**Consultation Response from KC,
Trees**

2024/93189 Unit 19-20, Headfield Mills, Savile Road, Savile Town, Dewsbury, WF12 9LQ

Erection of single storey extension, external alterations to shopfront to front and side elevation, change of use of part vacant area into class E Cafe and formation of car park access

Date Responded: 13/02/2025

Drawn by	Date	App'd	
AM	02/24	-	
Drawing no	Project no	Scale @ A3	Rev
PL-01	23-918	1:200	-

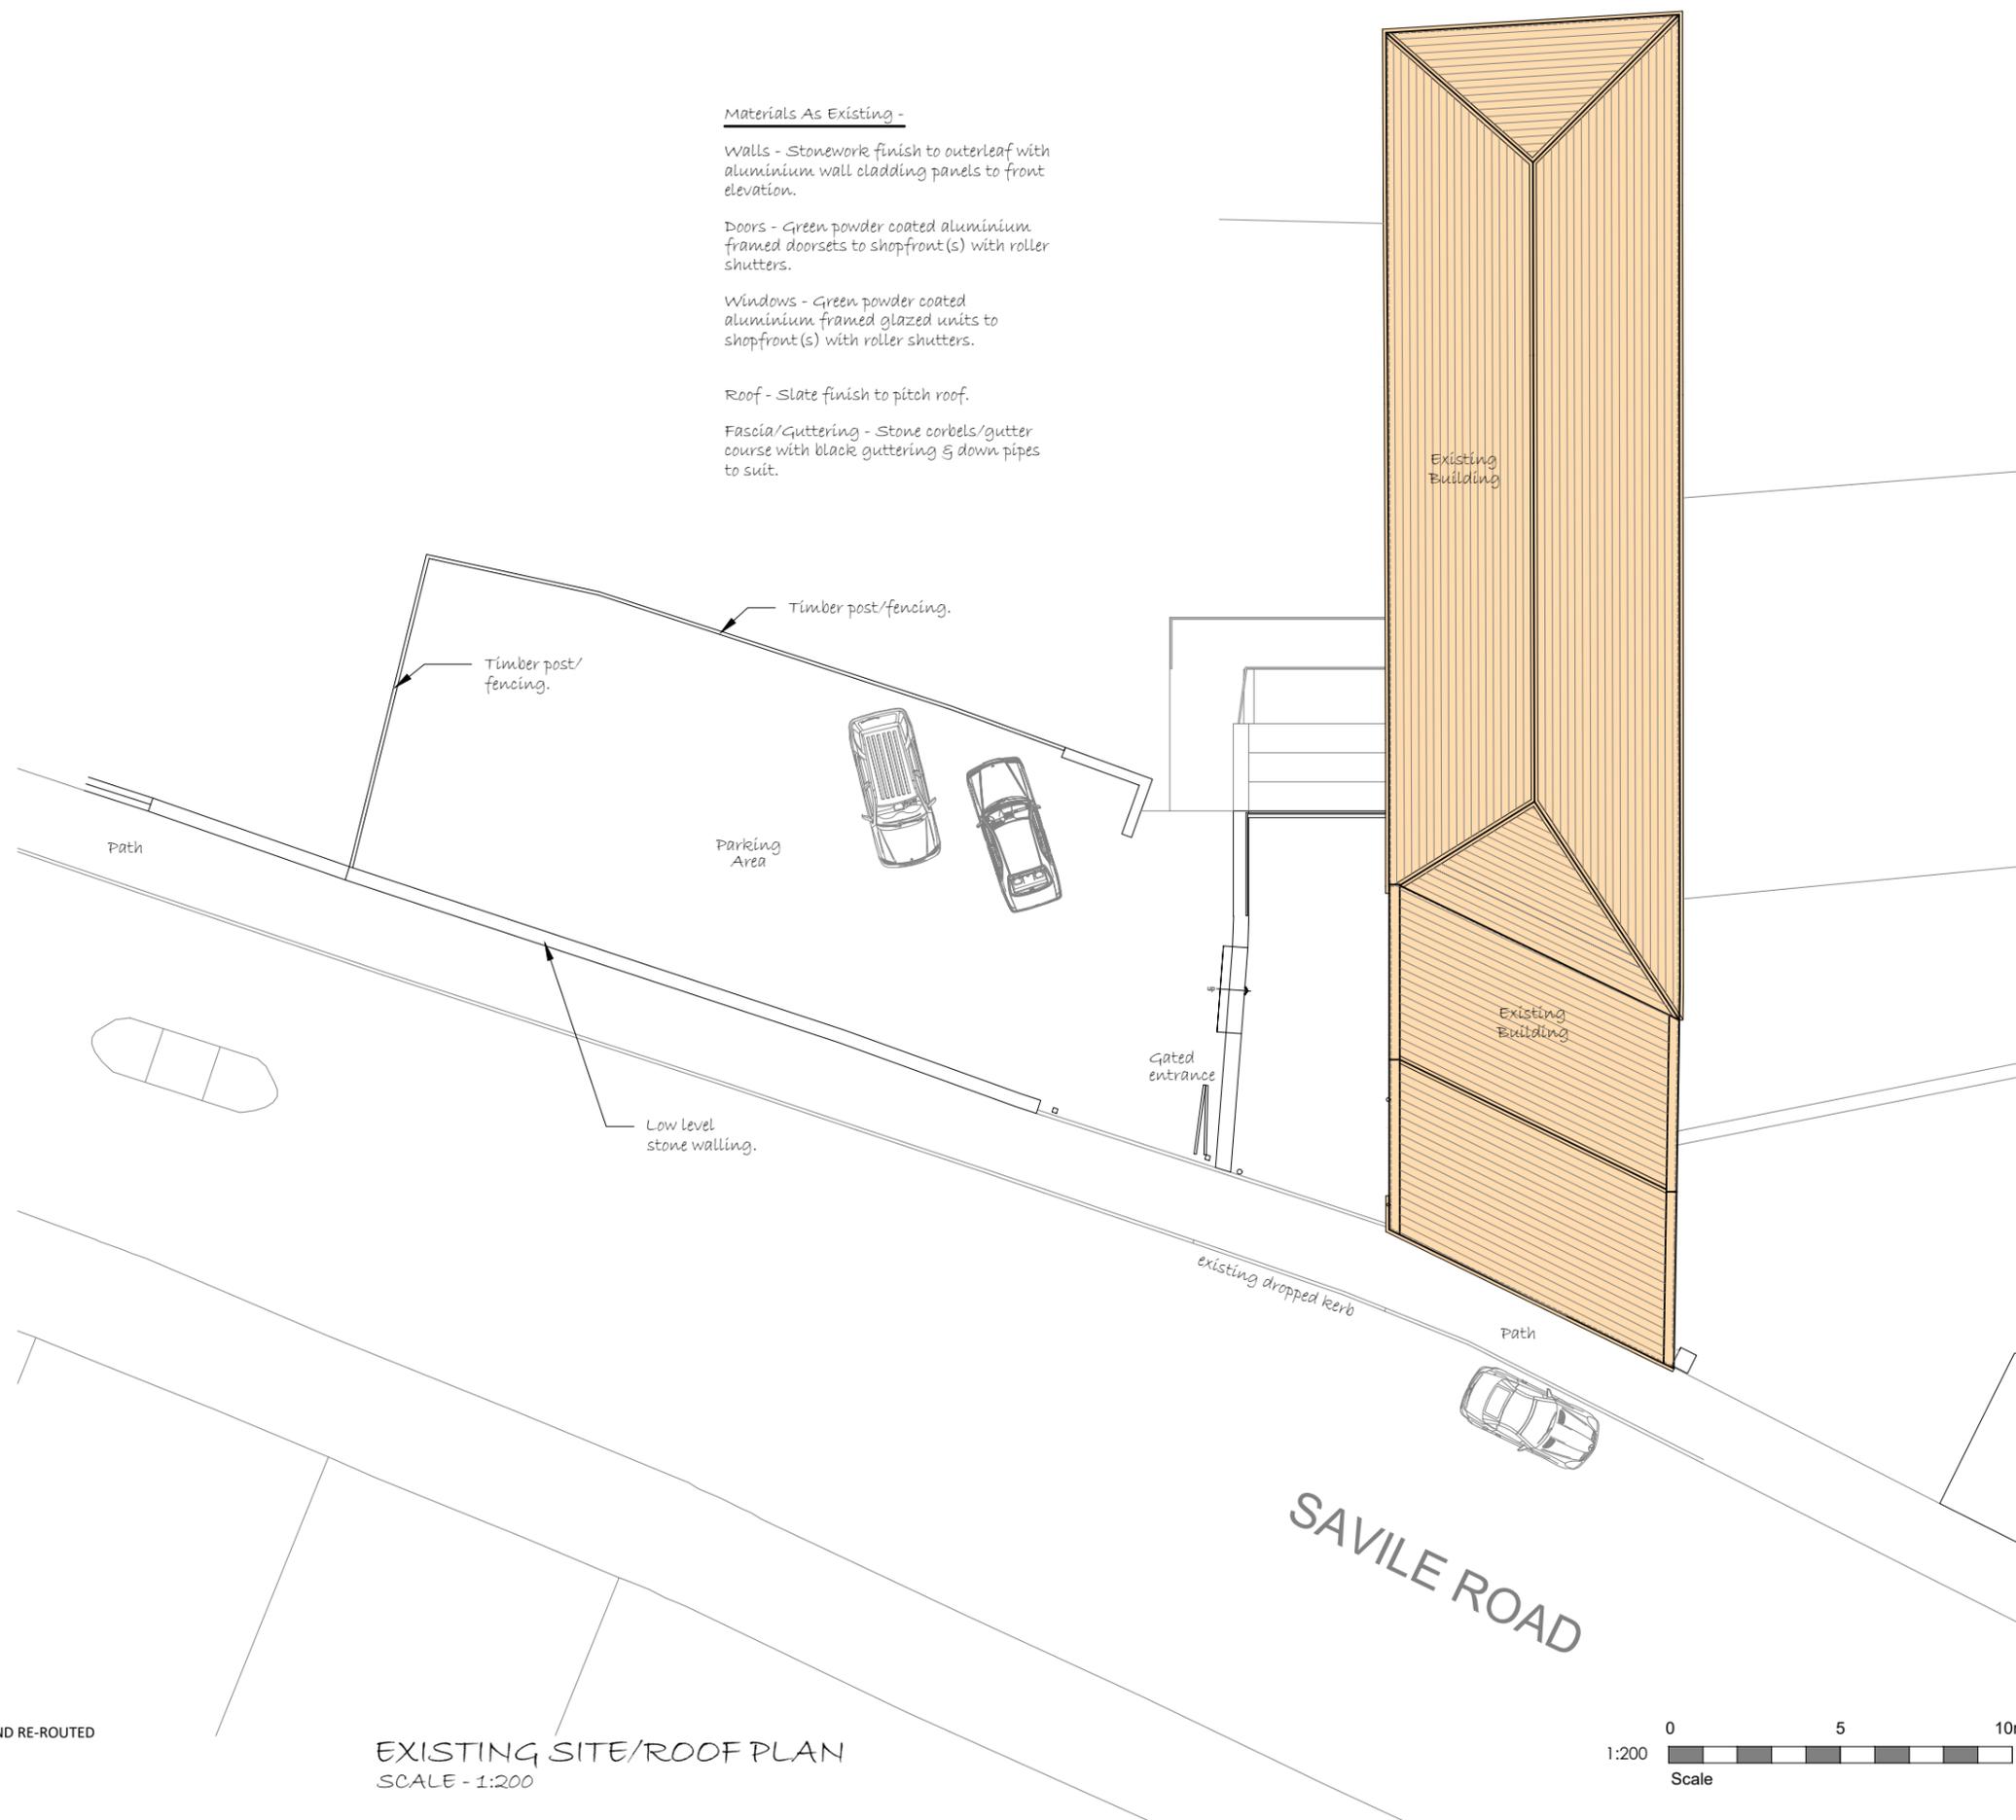
However, there are potential canopy conflicts with T1 and the construction of the proposed extension. The height of any machinery used to construct the extension should be considered against the height of the canopy and measures should be implemented to reduce any risk of accidental damage to the lower branches of the tree occurring during the works.

Additionally, the RPAs of T1, T2, T3 and T4 are situated within the carparking area. To avoid disturbing the roots of these trees, no ground level changes or excavations should be carried out within the RPAs.

Additionally, to avoid negatively impacting the long-term health of the trees the car park should be finished with a suitable permeable surface to allow for the movement of water and air. Ideally a three-dimensional cellular confinement system would be used as per recommendations in BS5837: 2012 (7.4).

No objections from an arboricultural perspective subject to the following conditions:

1. An AIA/AMS will be submitted to Kirklees Council to demonstrate how the retained trees will be protected throughout development from any arboricultural impacts associated with the proposals.
